Our Ref: P/86/19/HH

**Town & Country Planning Act 1990 (as amended)
Town & Country Planning (Development Management Procedure) (England) Order 2015
Application for Planning Permission for Works or Extension to a Dwelling**

Development 2 Storey rear extension single storey front extension and garage conversion
Location 11 Downlands Close Pagham

Block Plan

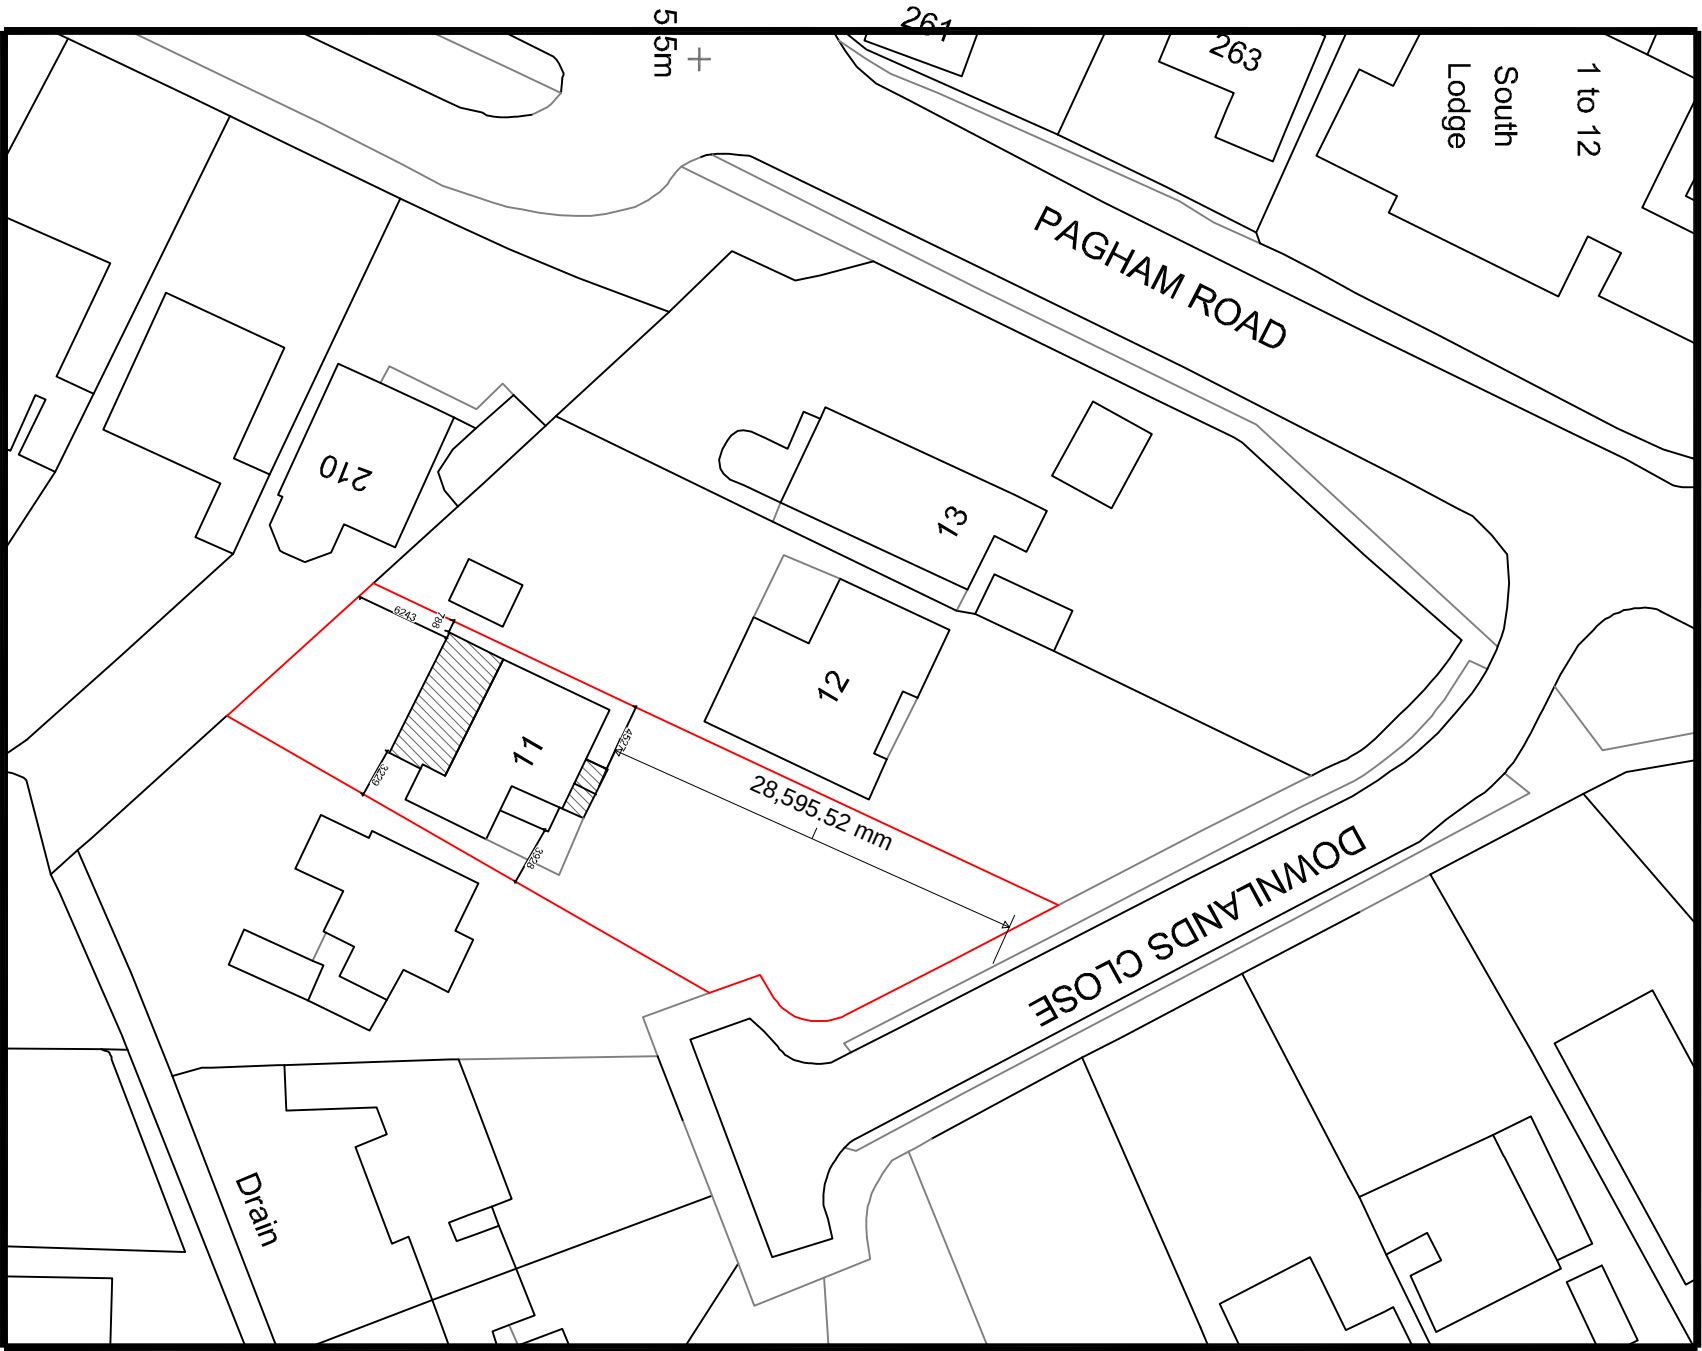
Block Plan

You are required to include dimensions on the block plan from the proposed extensions to all site boundaries.
